WELWYN HATFIELD COUNCIL – DEVELOPMENT CONTROL
DELEGATED REPORT

APPLICATION No:	S6/2008/679/FP
------------------------	-----------------------

The application seeks full planning to erect a single storey rear extension with dimensions of 3.3 metres in depth by 9.3 metres in width to provide for an extended living room and play area.

Drg.No: AT/226/02A

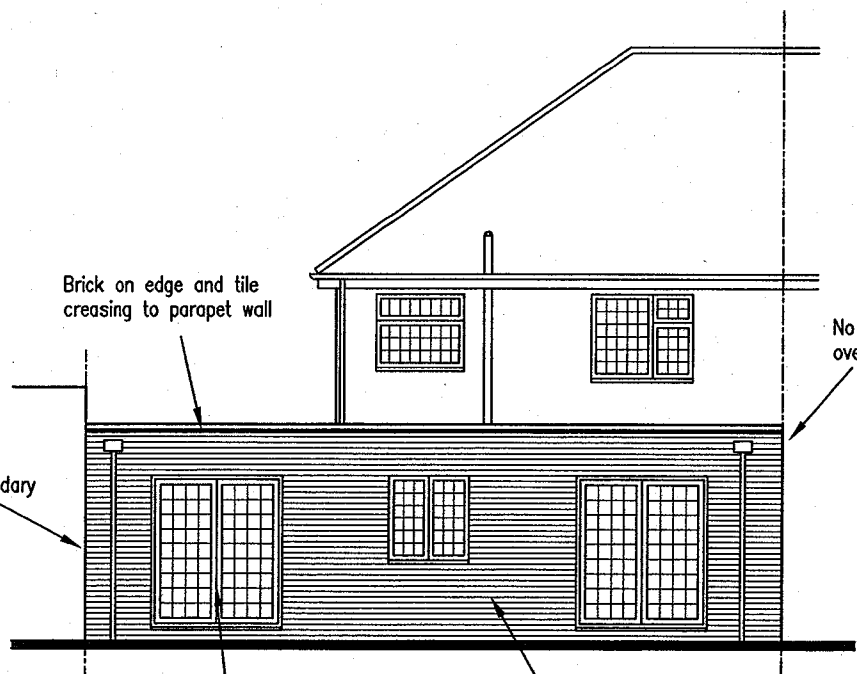
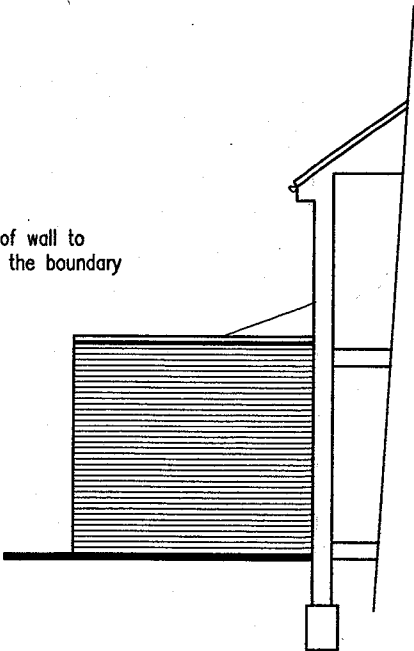
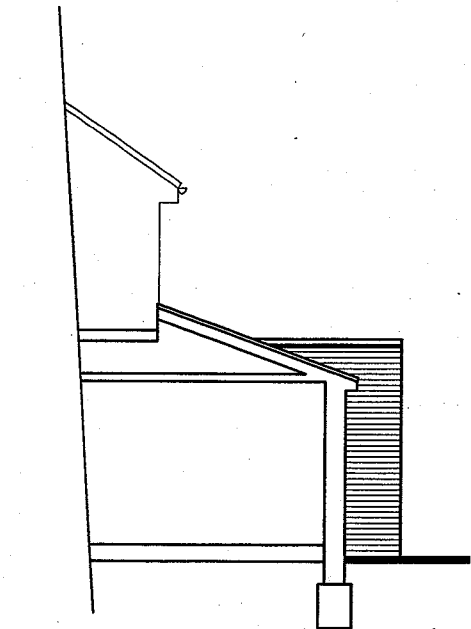
The property at 373 St Albans Road West is a semi-detached dwelling, which is a mirror image of the application dwelling, and the rear of this neighbouring property has not been extended. A 1.5 metre close-boarded fence is the current side common boundary treatment along this elevation and there is a terrace area directly in front of full height glazed patio doors.

The proposed extension would be approximately 0.6 metres from the edge of this glazed patio door and the flank of the proposal would be directly west.

Given this separation distance and the orientation, it is acknowledged that there would be some overshadowing to this neighbouring rear terrace and loss of sunlight/daylight to the lounge, more so during the second half of the day, however local plan policies are not intended to preserve the existing daylight, but to ensure that a sufficient level remains.

Taking into account these factors, it is considered that the depth of the proposed extension is towards the upper limits, but on balance, the proposal would not result in a significant loss of either sunlight/daylight to either the outside rear open amenity space or the rear habitable ground floor room.

Furthermore, it is also considered that the scale and height of the flank wall would not be overbearing or dominant to the aspect on this neighbour's property, as it would only have a limited impact on the wider rear garden and when viewed through the patio doors.

Proposed ground floor plan

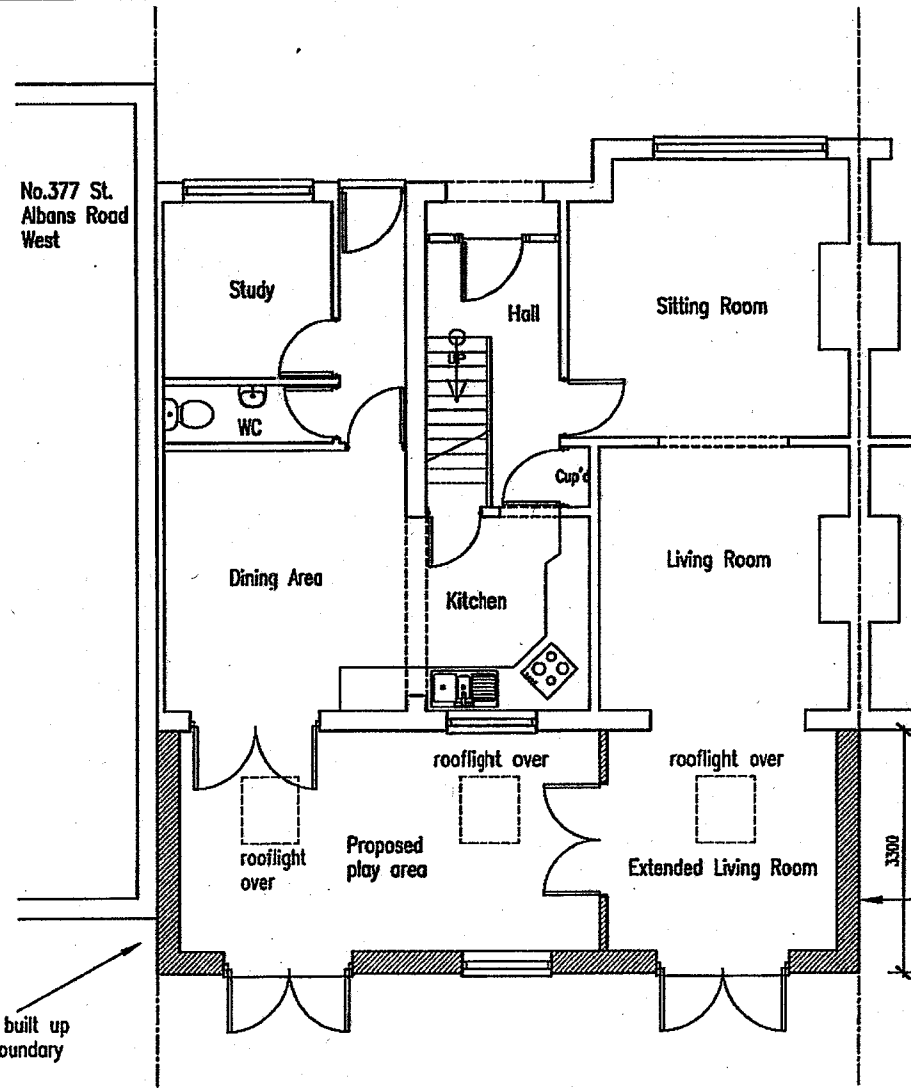
Additionally, the proposed rear depth of 3.3 metres is considered to be in scale to the parent property.
